APPLICATION NO. 03023 00696	PROJECT NO. 1002351
PROJECT NAME Seville Subd. #5	
EPC APPLICATION NO. (Margo)	
APPLICANT / AGENT Suru - Tek Russ Hugg	PHONE NO. 897-3366
ZONE ATLAS PAGE A-10

FINAL PLAT

# ONE STOP COMMENT FORM LOG

PARCEL A

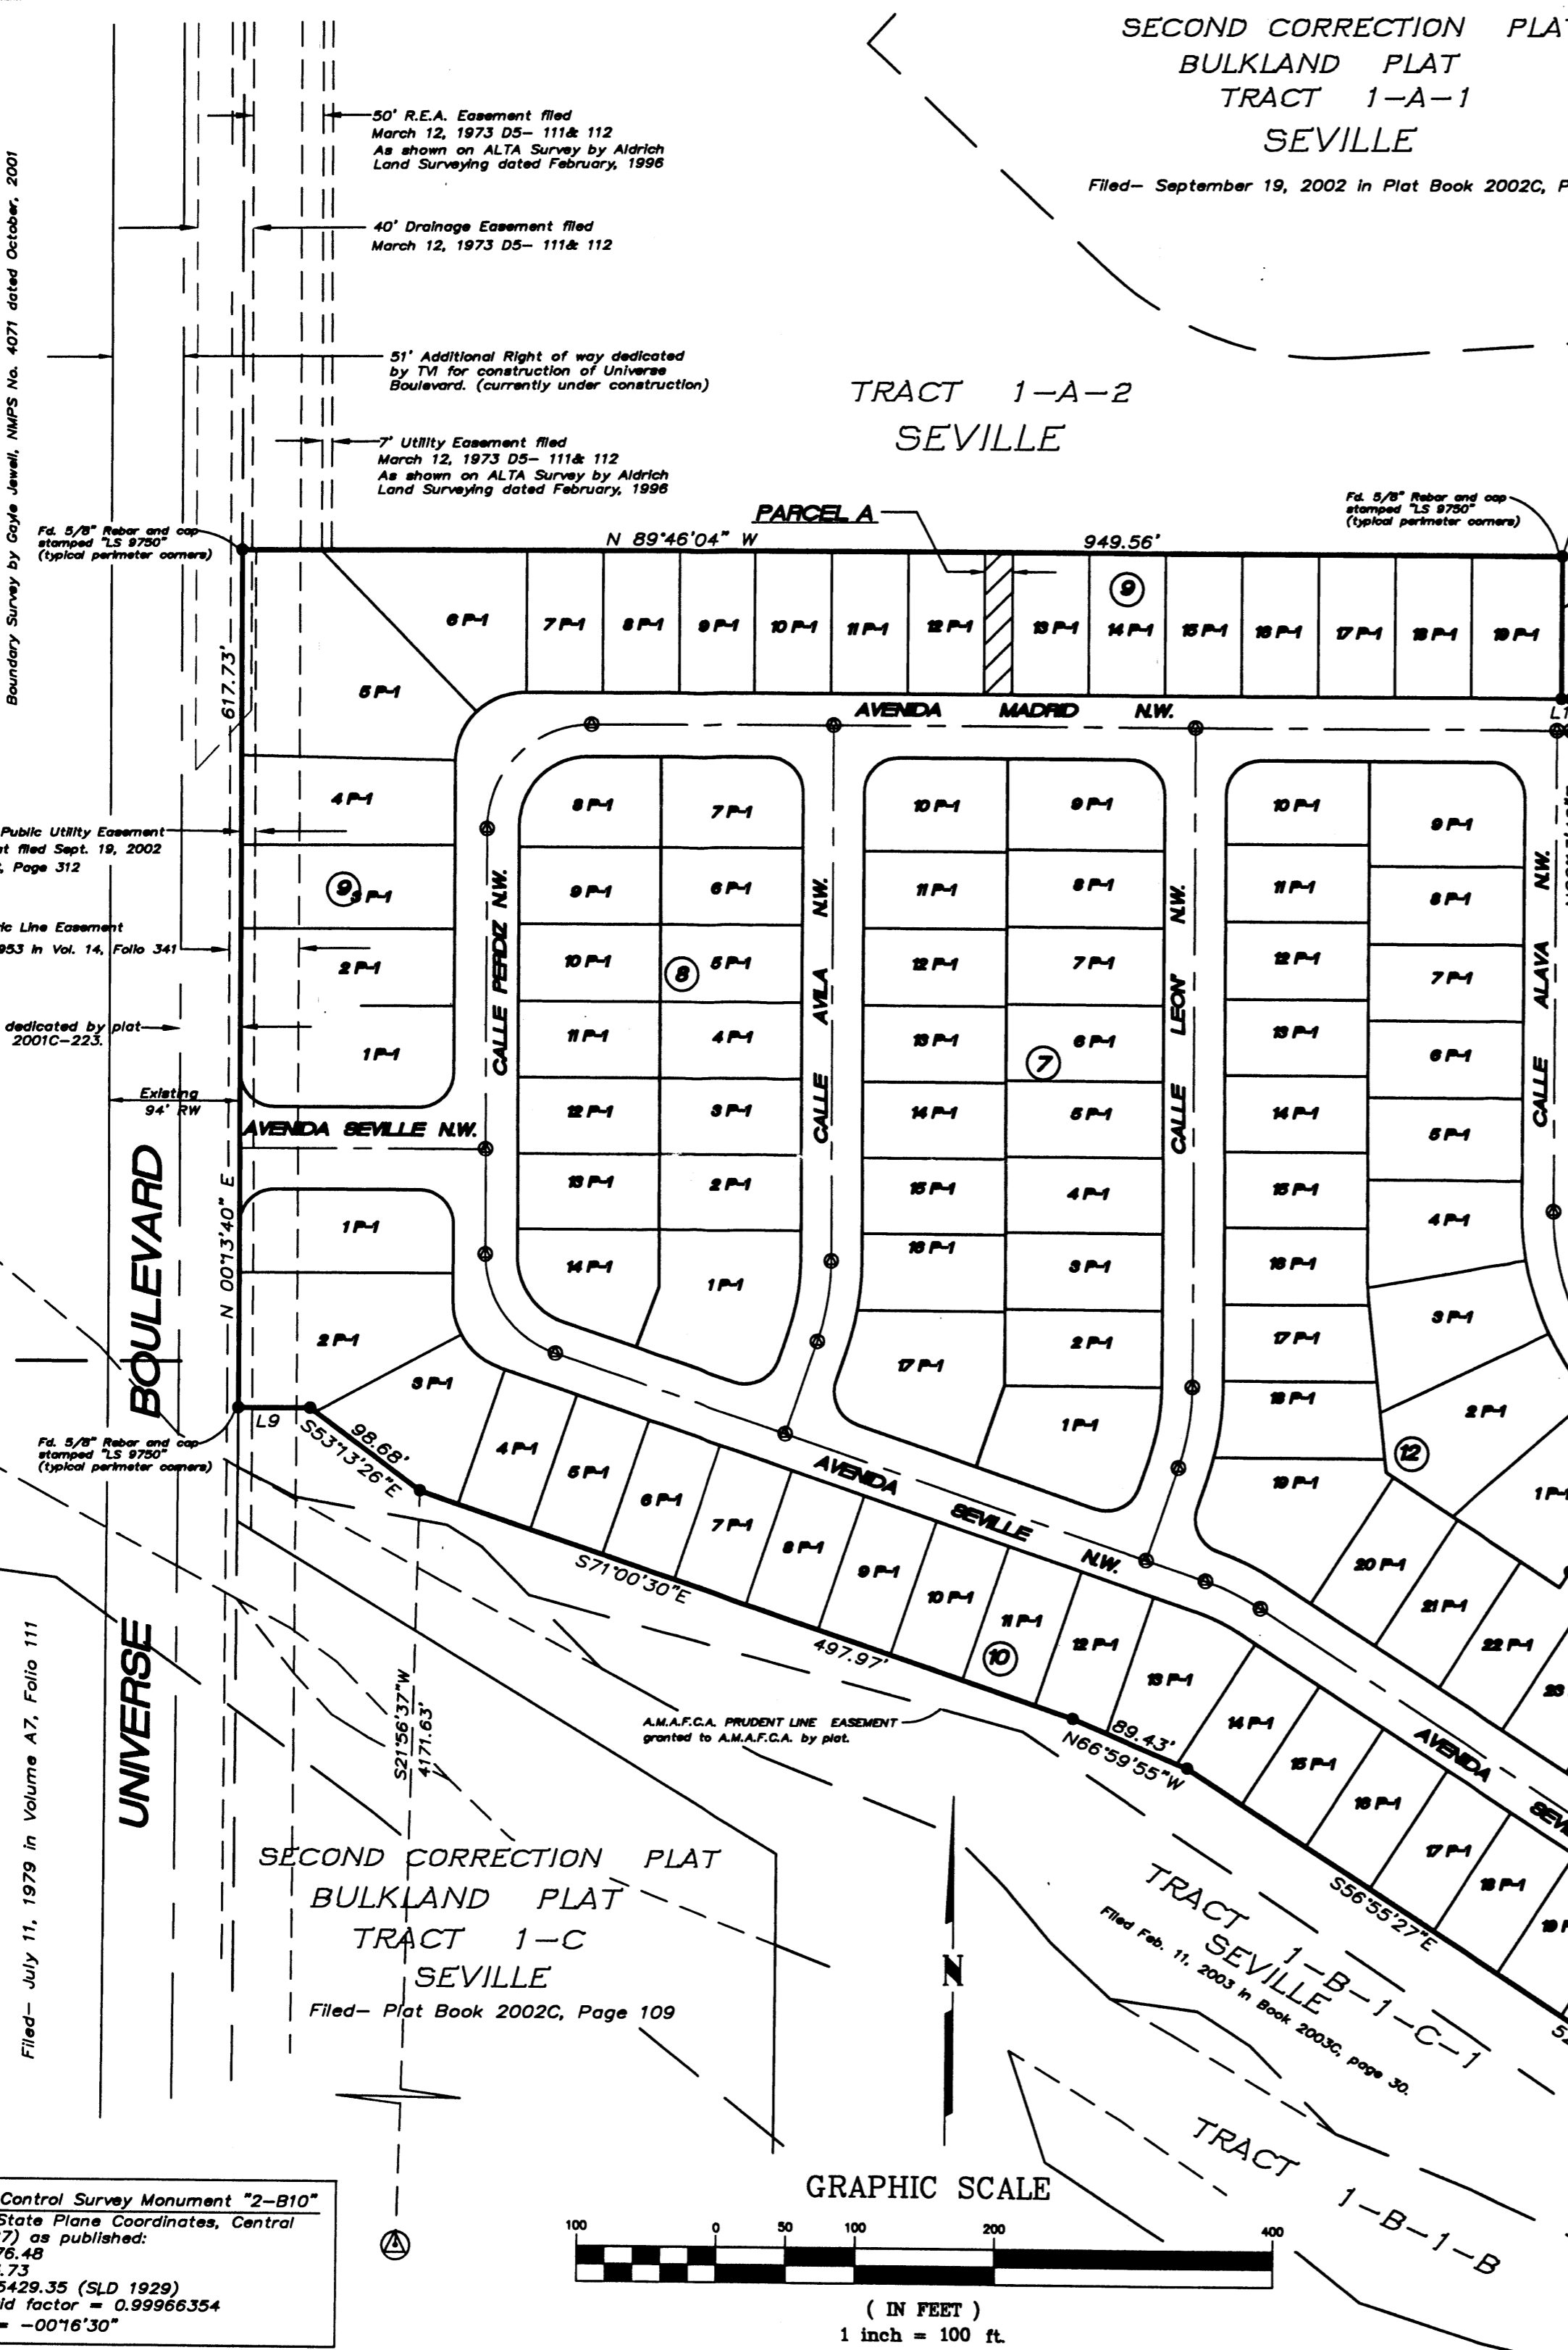
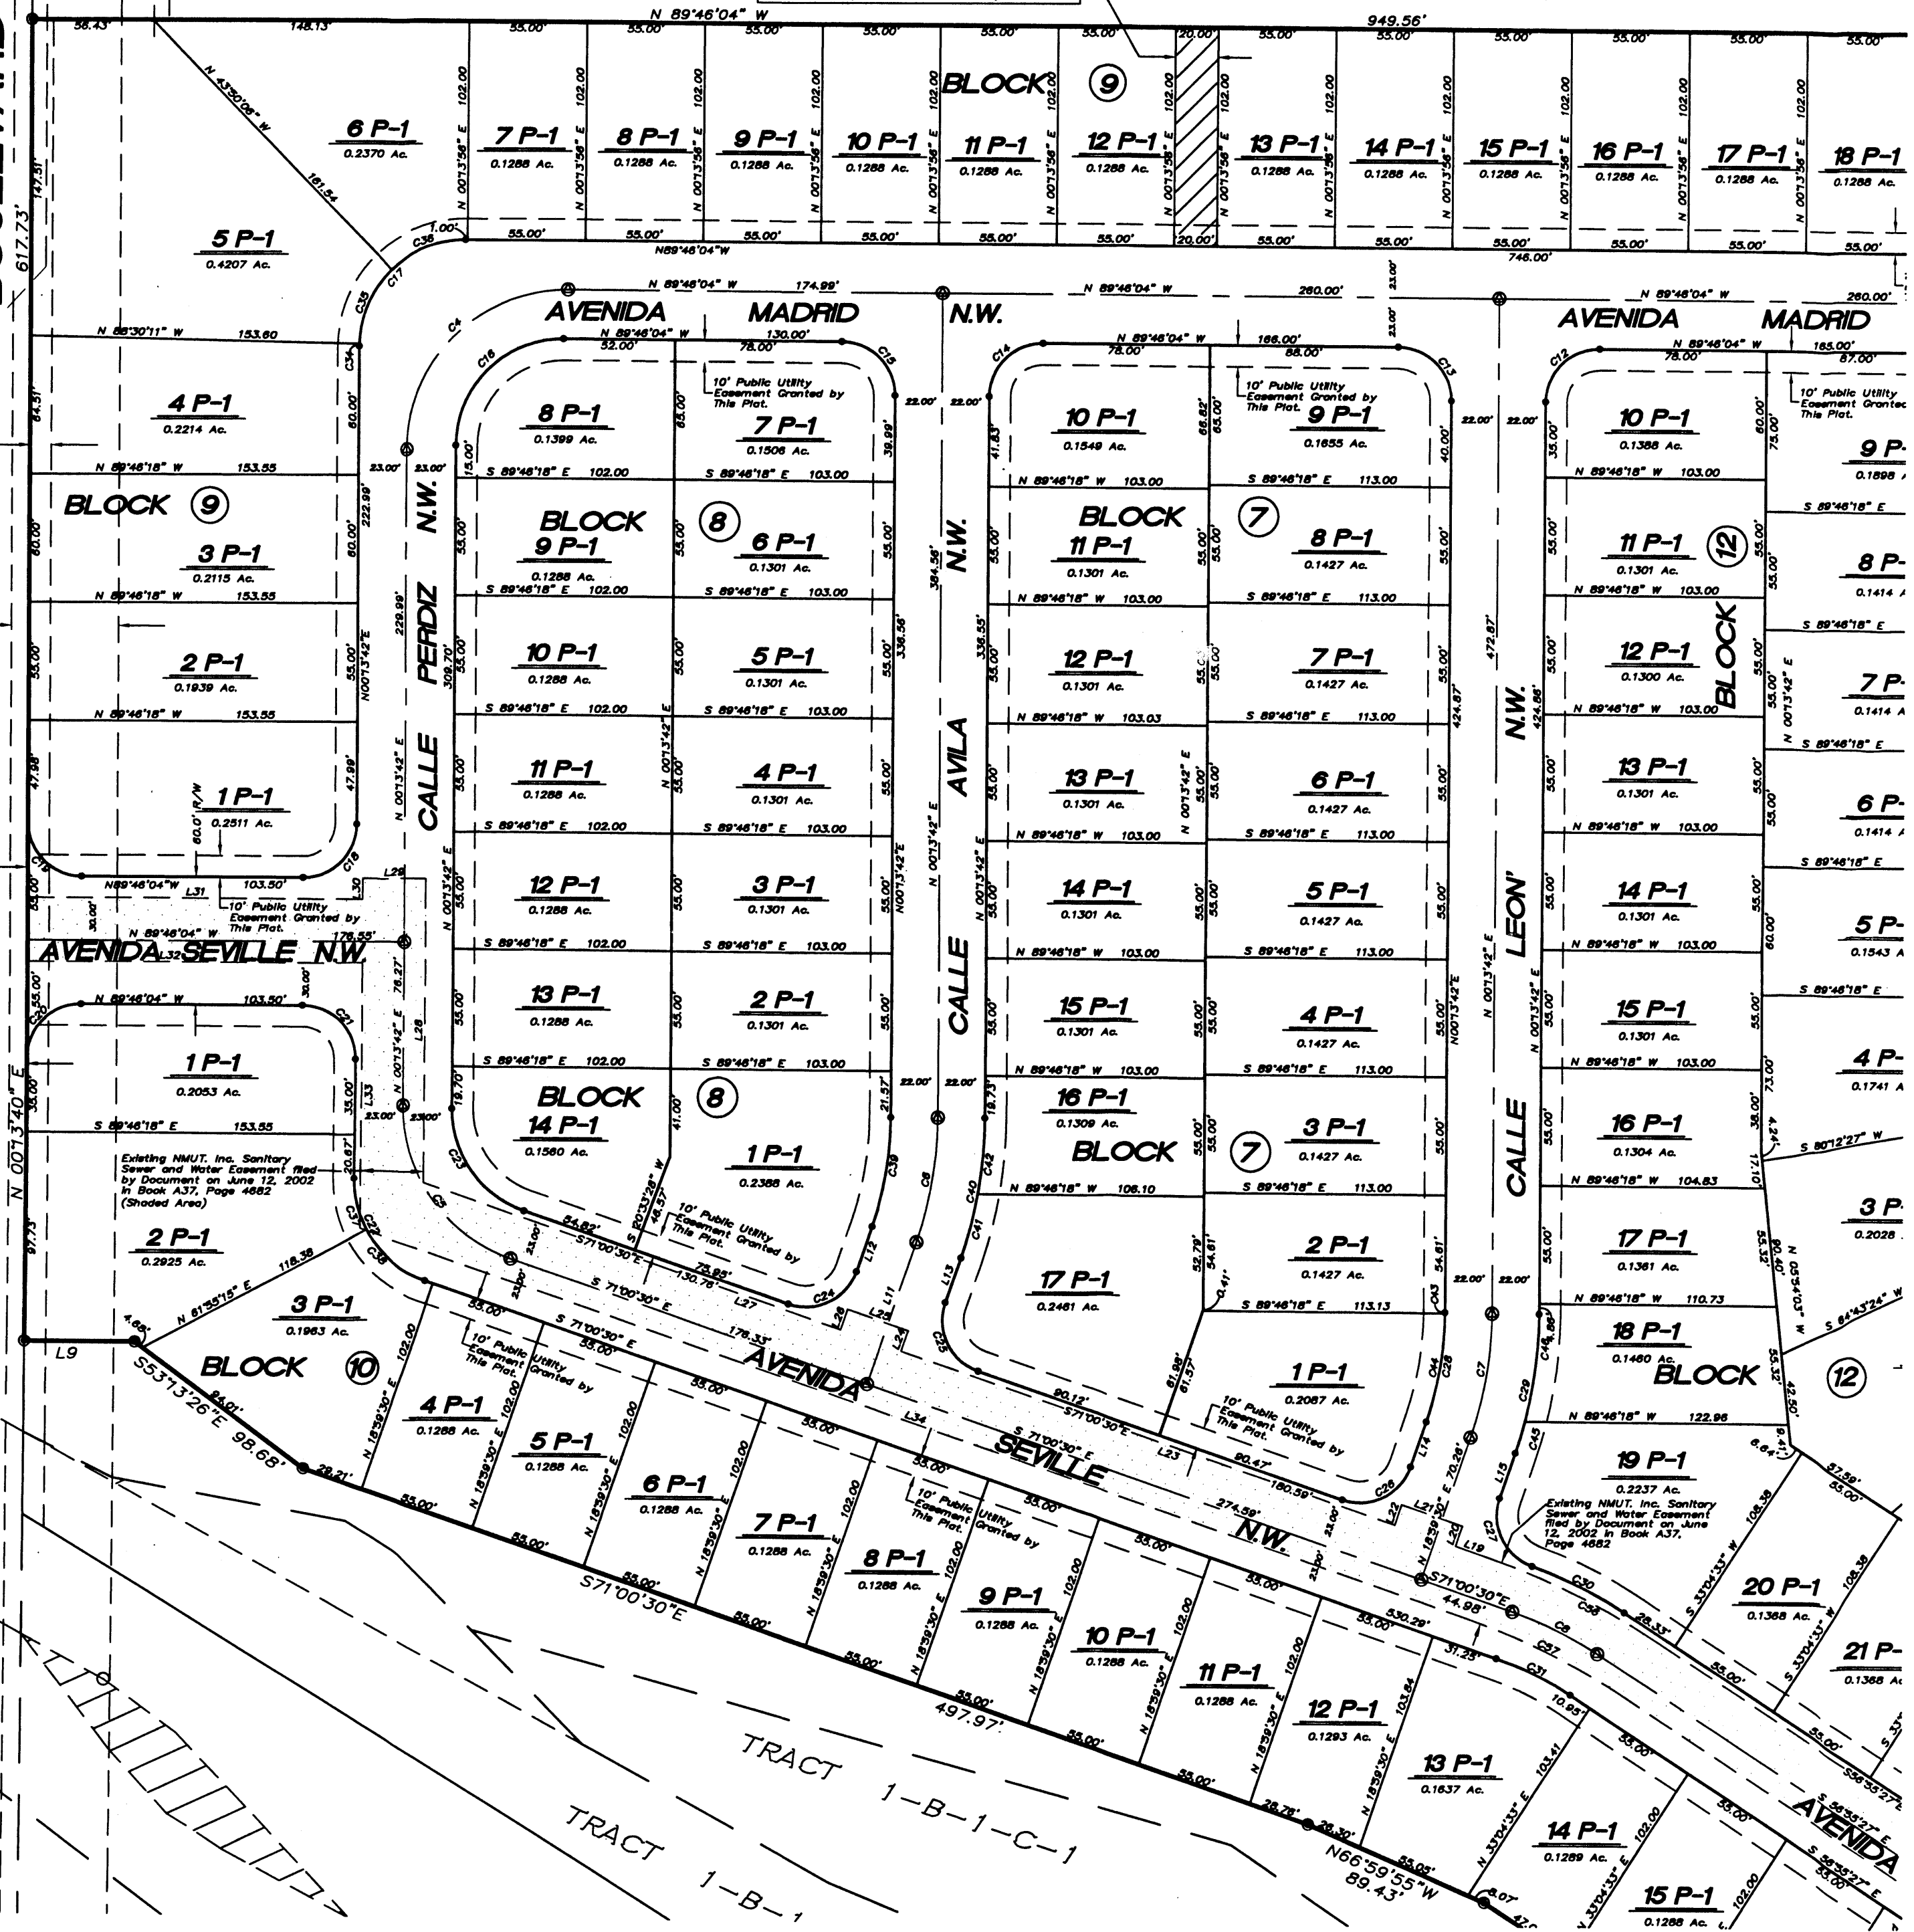
TRANSPORTATION DEV (505) 924-3990			
PLANS DISAPPROVED	DATE 5-02-03	DATE	DATE
PLANS APPROVED	DATE 5-08-03	DATE	DATE
COMMENTS:			
1- <del>What</del> What department is TRACT 'A' dedicated to?			
2- Any changes since preliminary PLAT Approval.

UTILITY DEV (505) 924-3989			
PLANS DISAPPROVED	DATE 5/5/03	DATE	DATE
PLANS APPROVED	DATE 5/5/03	DATE 5/9/03	DATE
COMMENTS:			
✓ - Dedication of parcel 'A' is unacceptable.			
✓ - Need to Release NMUT Sanitary Sewer Easement under Avenida Seville NW prior to / with Final Plat.
